Memo

Ref 2162570C-DMS-WAT-005 RevD

Subject PB responses to Kalf & Associates February 2013 comments on Groundwater Assessment

Figure 5.2 Predicted storage and river losses from mine dewatering

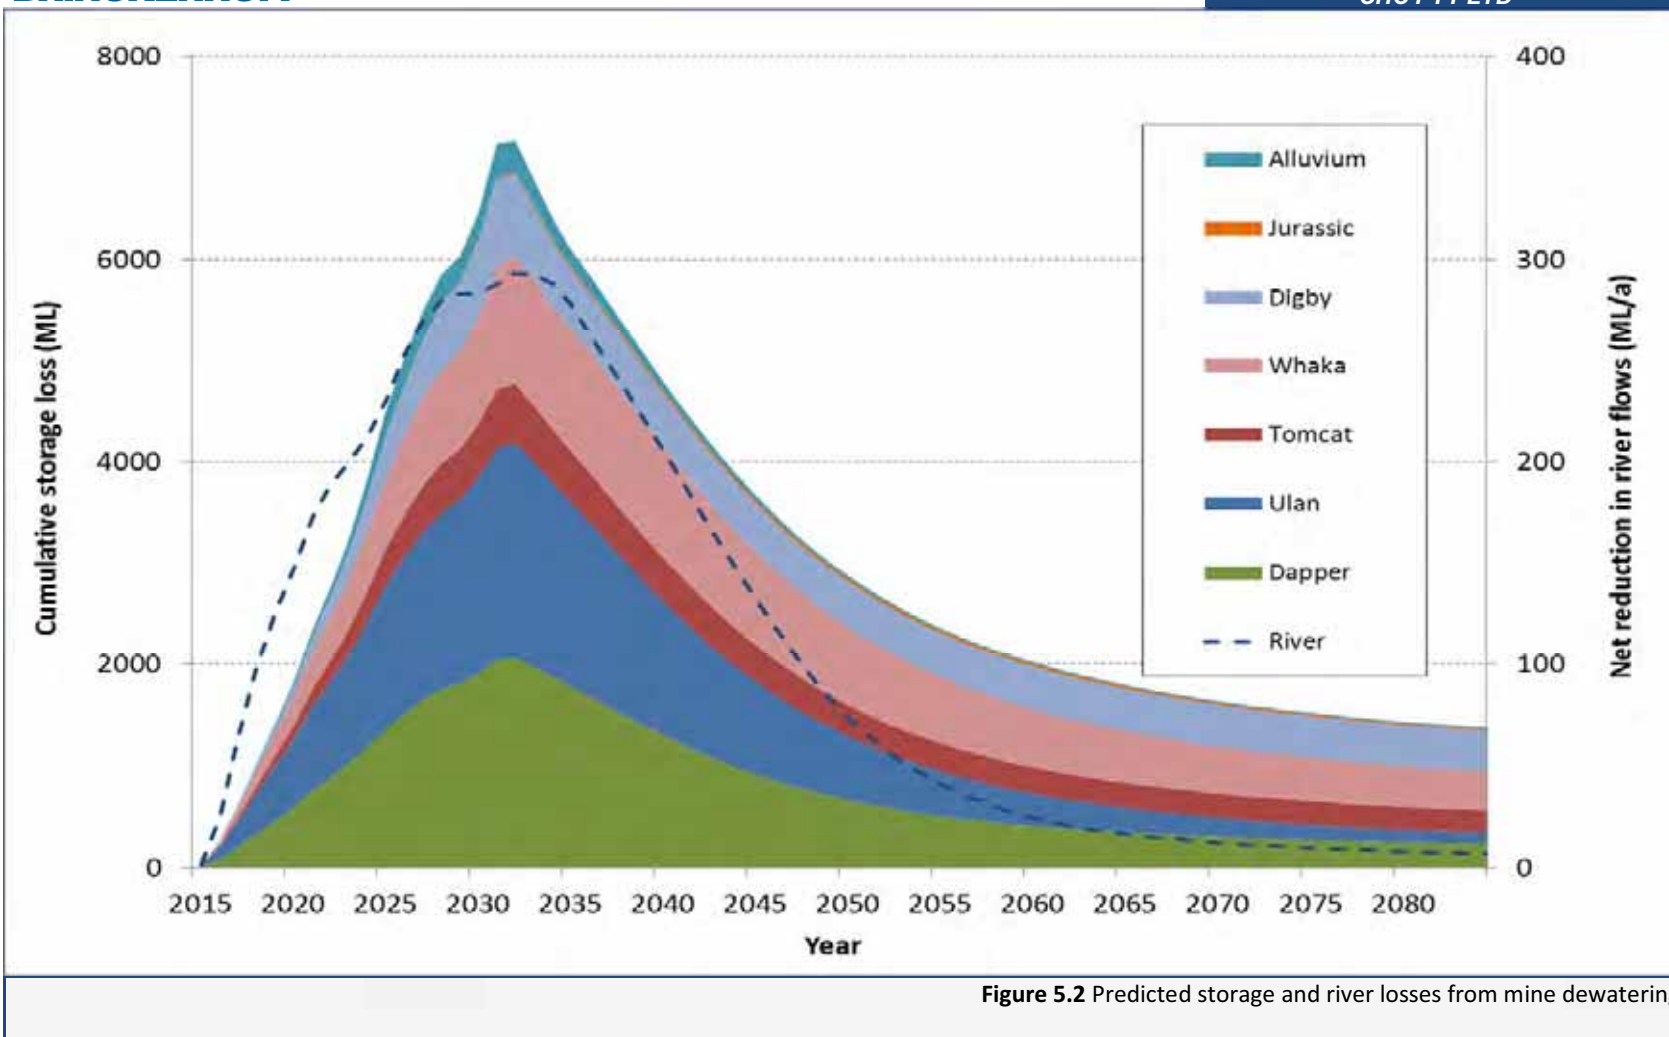
No.	Summarised comment	PB Response
1	Executive Summary. Page xiv. The report mentions "river losses" of 469 ML/a. Does this include losses also from the creeks (e.g. Sandy and Laheys). (see point 5 below)	"River losses" have been calculated for all rivers in the model. This includes the Talbragar River and tributary creeks.
2	Page xv. When losses from the alluvium are stated is this just Talbragar River alluvium or does include all streams.	Losses are from all alluvium including alluvium associated with tributaries of the Talbragar
3	The Equilibrium level of 373.9 mAHD in 100 years. What are the likely error bars on this value (i.e. the accuracy of this estimate)?	This is reported in Section 8.2.5 of Appendix E (Water Balance and Surface Water Management System) of the Surface Water Assessment – see Figure 1 below this table which is extracted from this section of the Surface Water Assessment. The pit lake remains a net sink feature under the range of stochastic model outcomes (which includes uncertainty in groundwater inflow).

Figure 5.6A Drawdown in water table aquifer after 21 years / end of mining

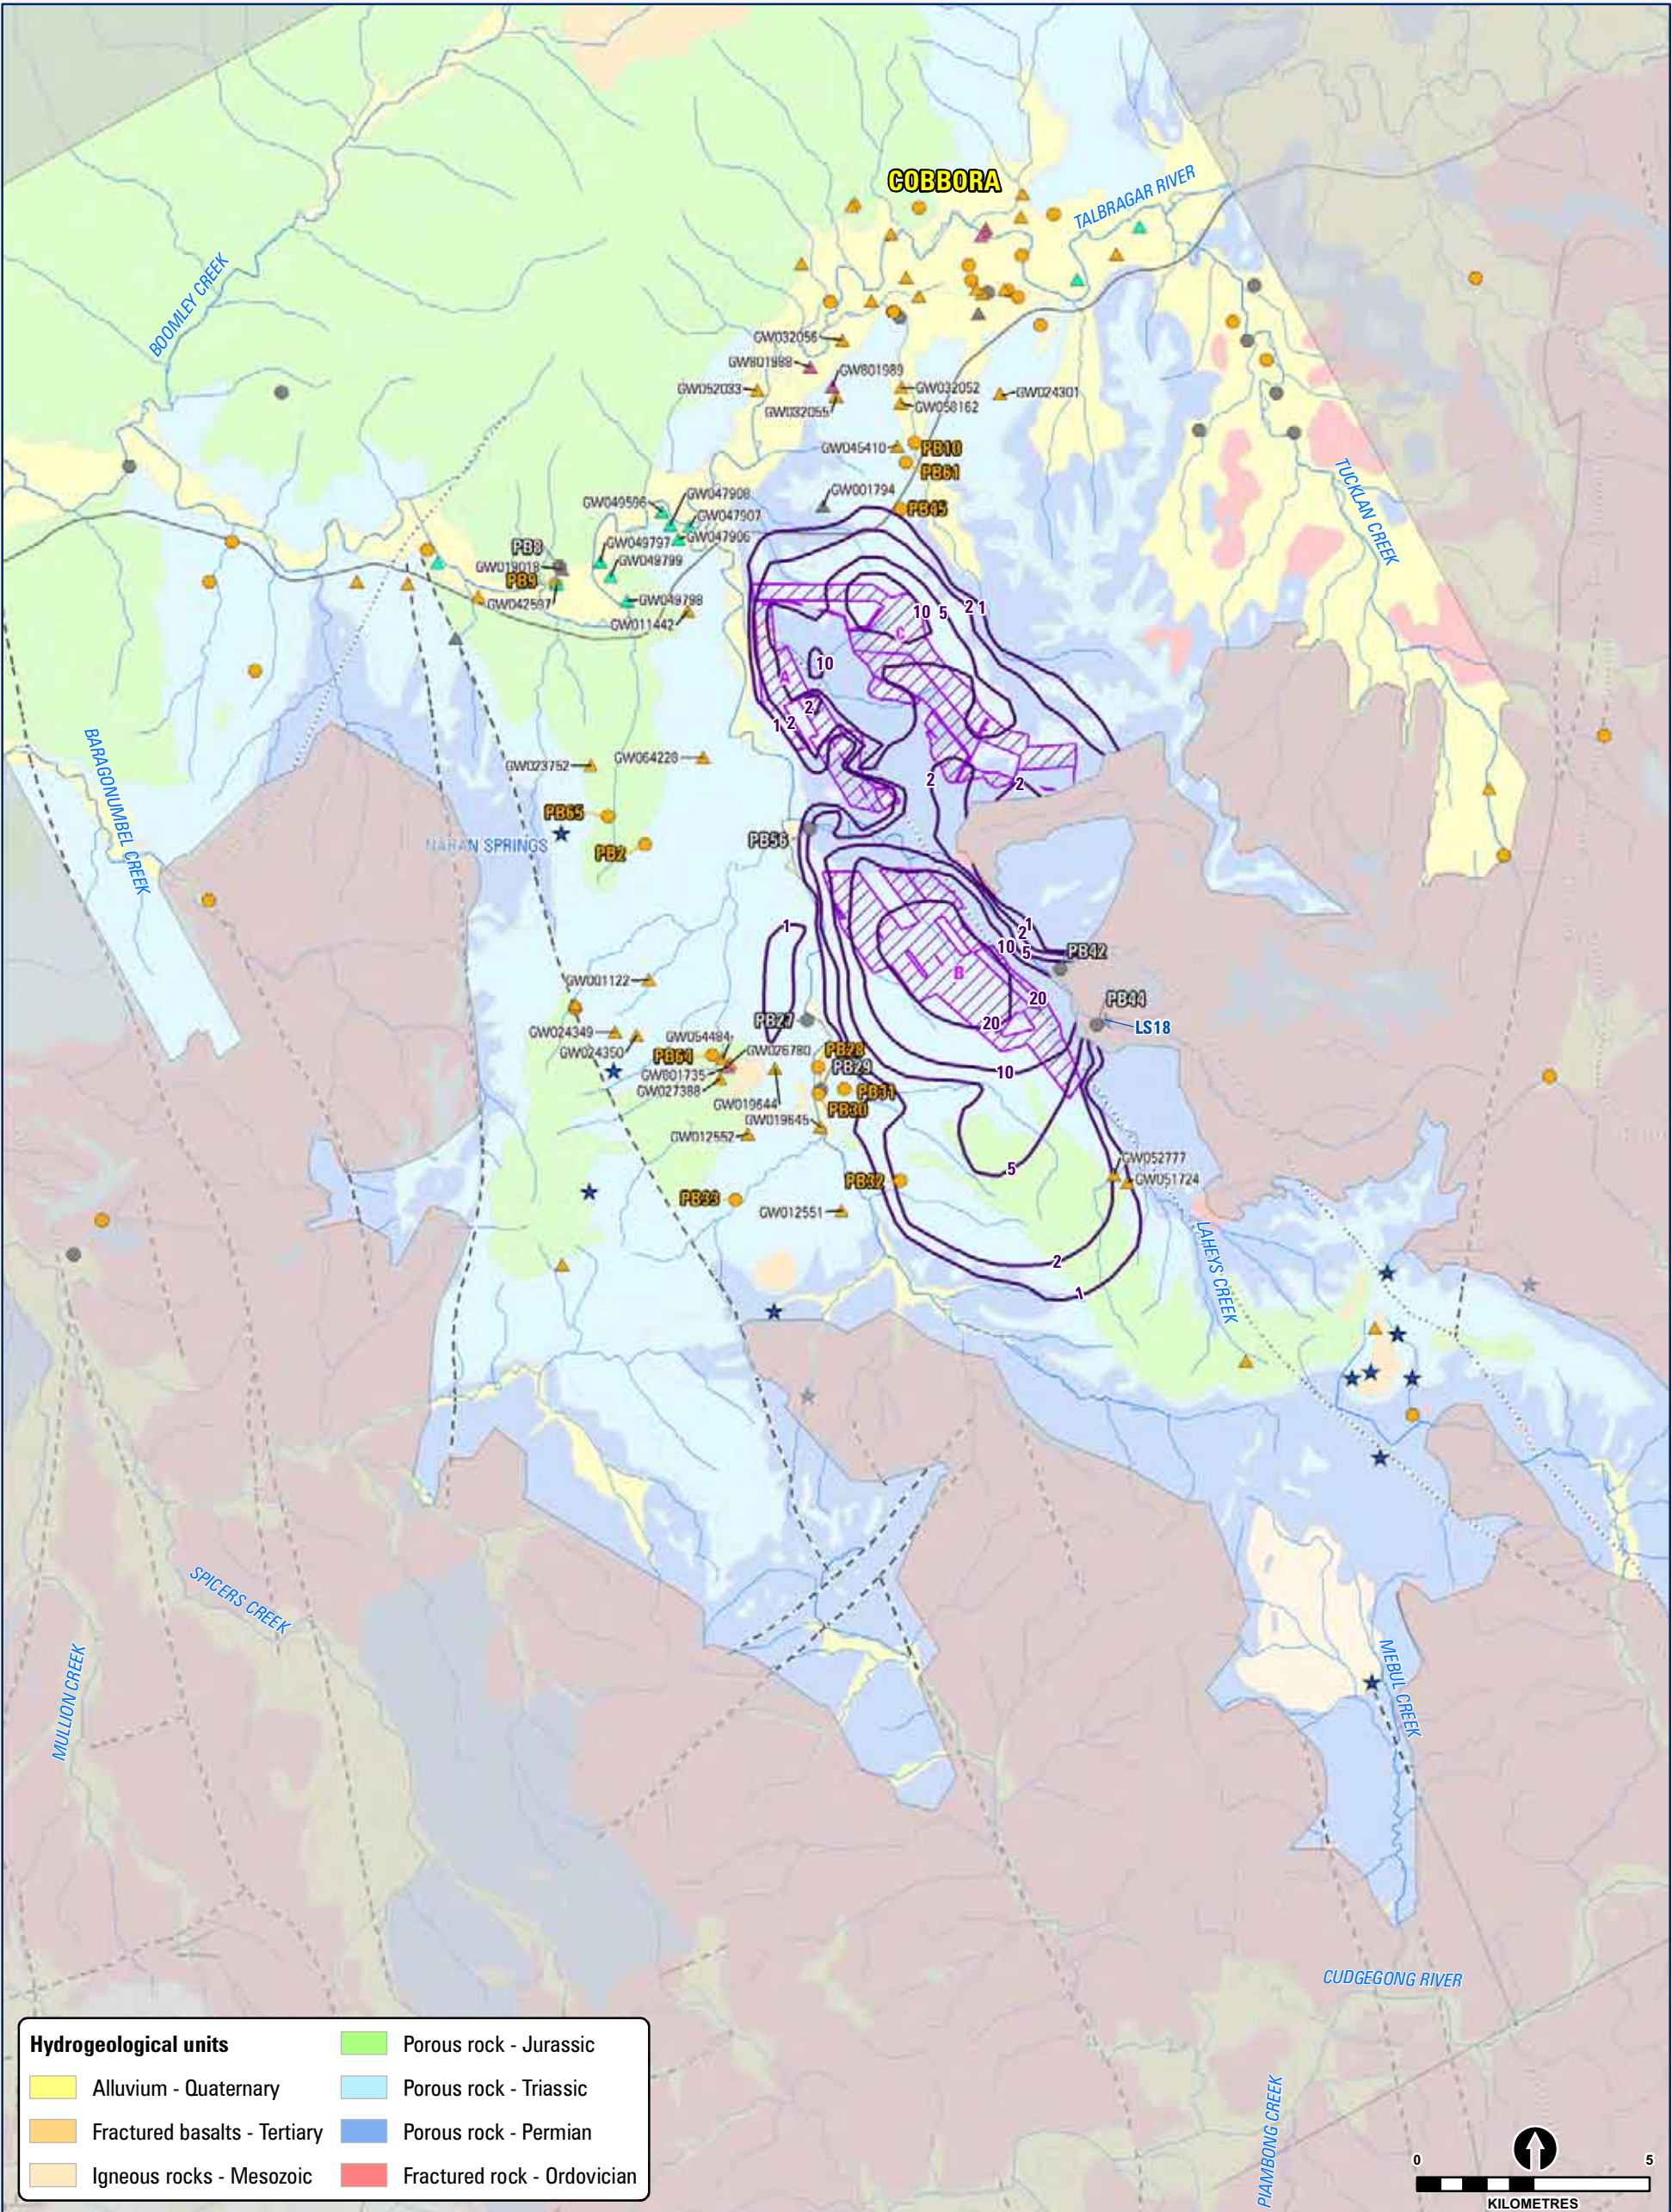
No.	Summarised comment	PB Response
5	<p>Treatment of creeks and rivers. As stated on Page 18 that Sandy Creek is ephemeral but it is seemingly providing a continuous source of surface water (Appendix H Figure 5.6D - see below)?. This is likely because of the way the Sandy Creek boundary condition has been set up as a constant creek stage ('river package') in the model thereby providing a continuous source of water with the consequent water table drawdown that decreases rapidly towards Sandy creek.? <i>[other text not reproduced here]</i></p>	<p>Comments related to using River cells are noted. The conceptualisation of streams and numerical treatment was discussed at length with our reviewer (Noel Merrick). Early iterations of the model used Drain cells and recharge. However, following initial reviewer comments these were replaced by River cells.</p> <p>The River type boundary was selected with the following reasoning:</p> <ul style="list-style-type: none"> Isotopic evidence indicates that groundwater within the alluvium is modern meteoric water, in contrast to the Permian strata which has ancient water (>30 ka) – refer to sections 5.7.1 and 5.7.2.2 in main report. This implies that the streams act as sources of episodic flood recharge even though the hydraulic gradient is towards the creeks during low flow conditions, and that the rate of recharge to the alluvium is potentially much greater than the flux of groundwater discharge from the Permian strata adjacent to the creeks. In this sense the alluvial systems act as weakly connected, rapid through-flow systems overlying a slower moving Permian groundwater system. Drains are therefore not an appropriate boundary condition (as pointed out by our reviewer) and would apply unreasonable conservatism to the model. River cells were used to represent the ongoing recharge due to episodic flooding in creeks over the long term. Induced vertical fluxes from the alluvium (and river) to the underlying Permian system during mining would be limited by the vertical permeability applied to the alluvium. This mechanism has been quantified by pumping test data. Pumping tests adjacent to Sandy Creek and the Talbragar River were used to estimate the leakage rate between the alluvium and Permian groundwater systems when the latter system was depressurised. Accordingly, a vertical anisotropy ($K_h/K_v = 1000$) was applied to the alluvium. The Stream routing package has been rarely used in groundwater modelling of mine impacts (based on a review of 18 recent groundwater assessments), and was not considered practical in this assessment. To implement the stream package realistically requires input from surface water models and also requires additional complex assumptions, which also carry significant uncertainty. <p>In summary the River boundary was considered the best approximation of ongoing stream flood recharge, on balance, given the high surface water runoff component in the creeks and typical 50% to 60% flow. However in response to the reviewers recommendation we have run an additional (highly conservative) model sensitivity scenario whereby the rivers provide no recharge to the aquifer. <i>The results are presented below.</i></p>
